Our ref: NO/2025/116706/04-L01
Your ref: 3/2025/0147
Date: 08 December 2025

PROPOSED DEMOLITION OF EXISTING BUILDINGS AND ERECTION OF SIX 2-BED AND ONE THREE-BED APARTMENT BUILDING TOGETHER WITH A TWO STOREY BUSINESS CENTRE AND ASSOCIATED PARKING AND BIN STORE.

PEEL STREET BUSINESS ESTATE, PEEL STREET, CLITHEROE, BB7 1RA

Environment Agency position

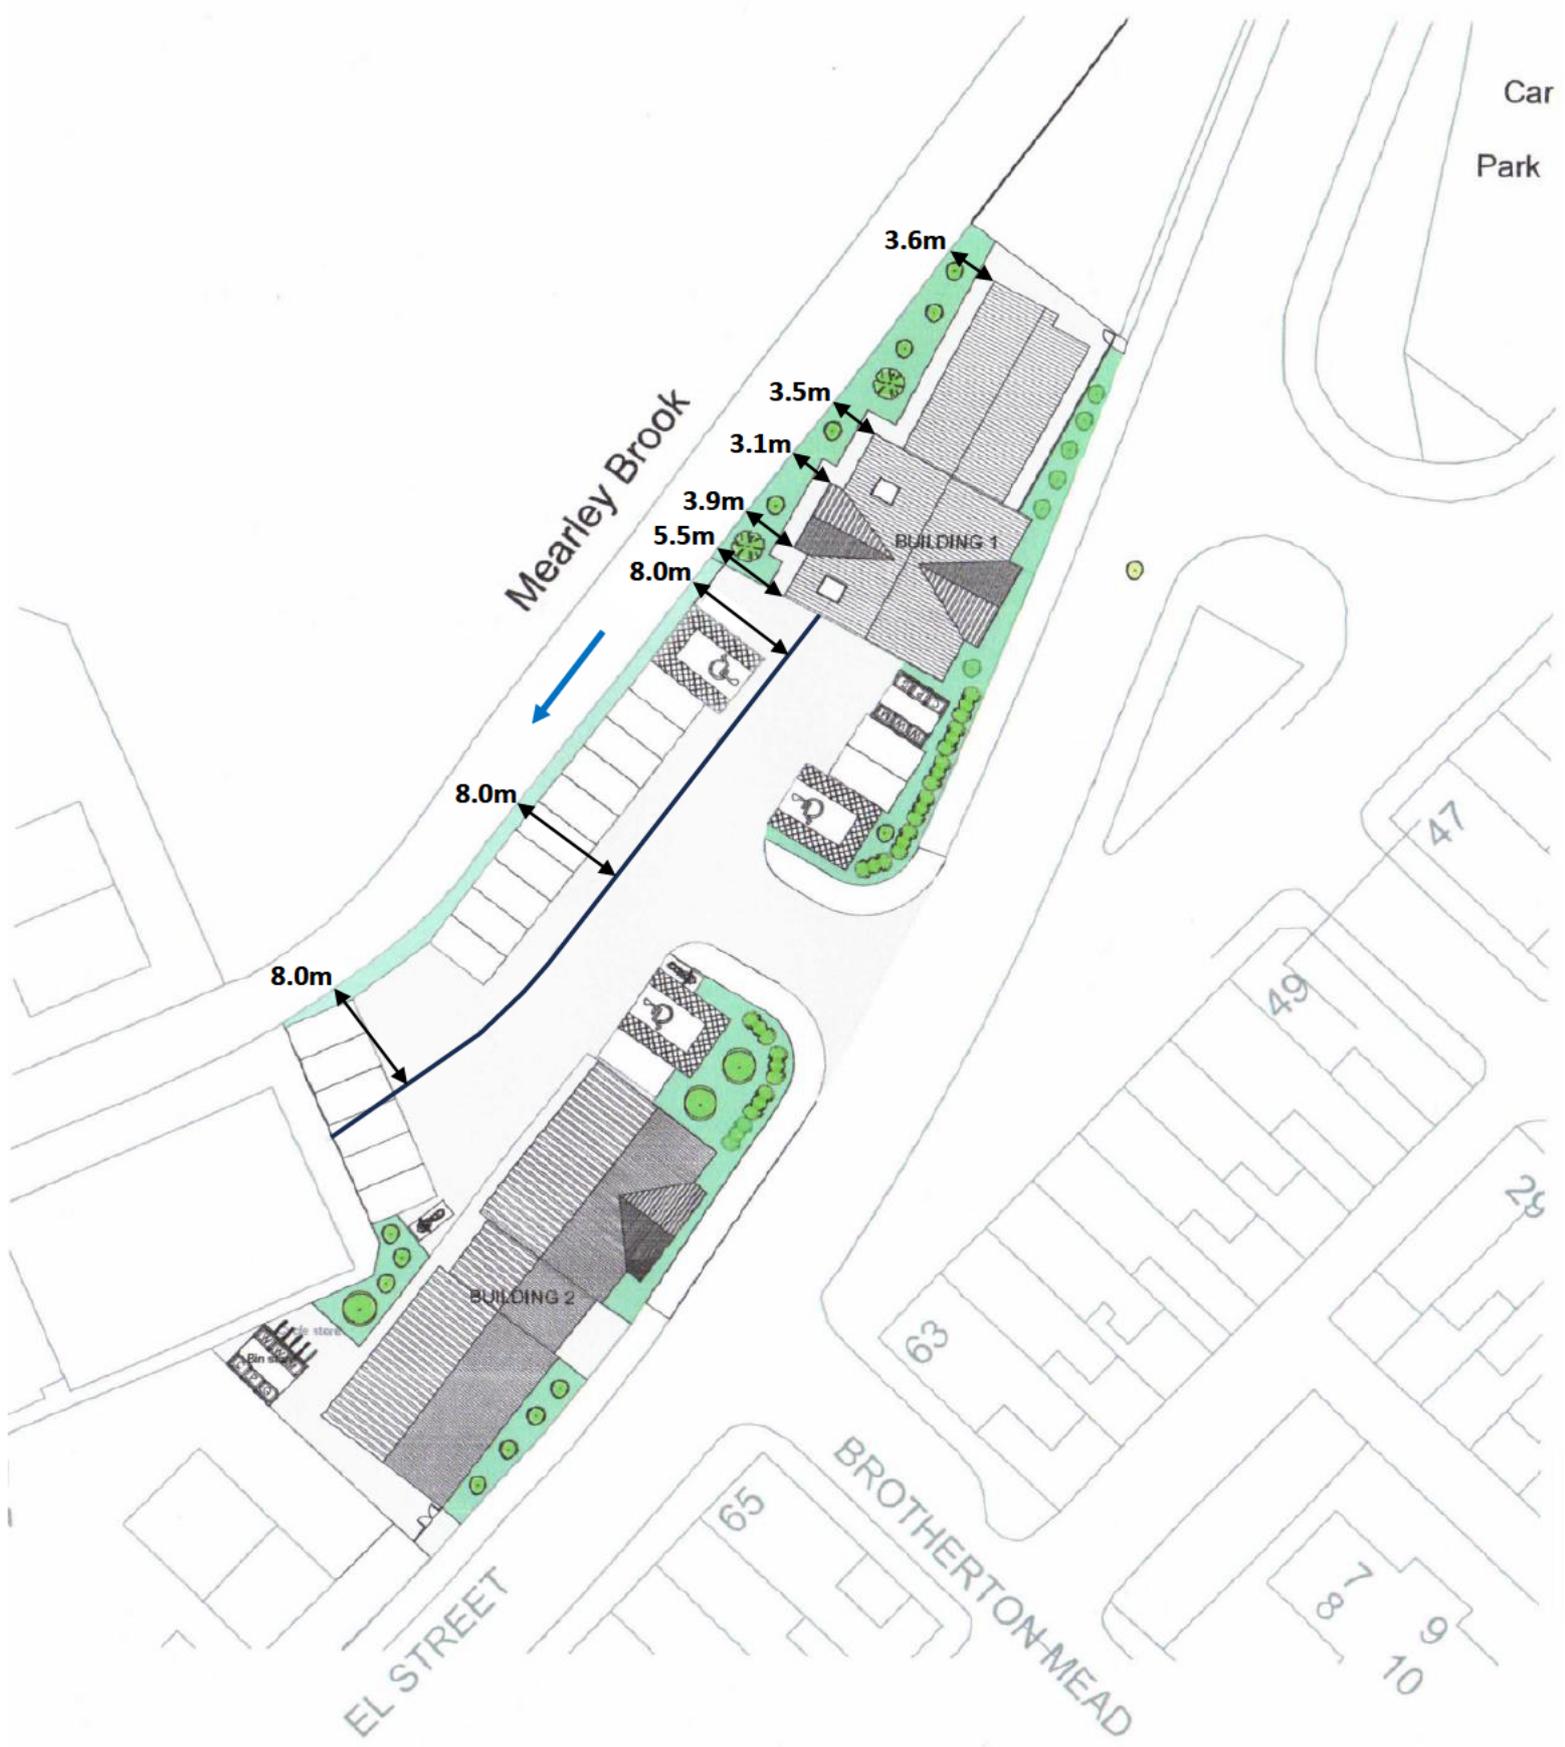
In our letter referenced NO/2025/116706/03-L02 and dated 15 September 2025 we maintained our objection to the development as the submitted amended plans did not satisfactorily address our earlier concerns regarding the close proximity of the buildings and proposed car parking to the top of the bank of Mearley Brook, which is designated as a Main River.

We have reviewed the agent's response letter, which includes an annotated plan with distances marked on and consider that it satisfactorily addresses our earlier concerns.

Subject to conditions below, we therefore withdraw our previous objection, dated 15 September 2025.
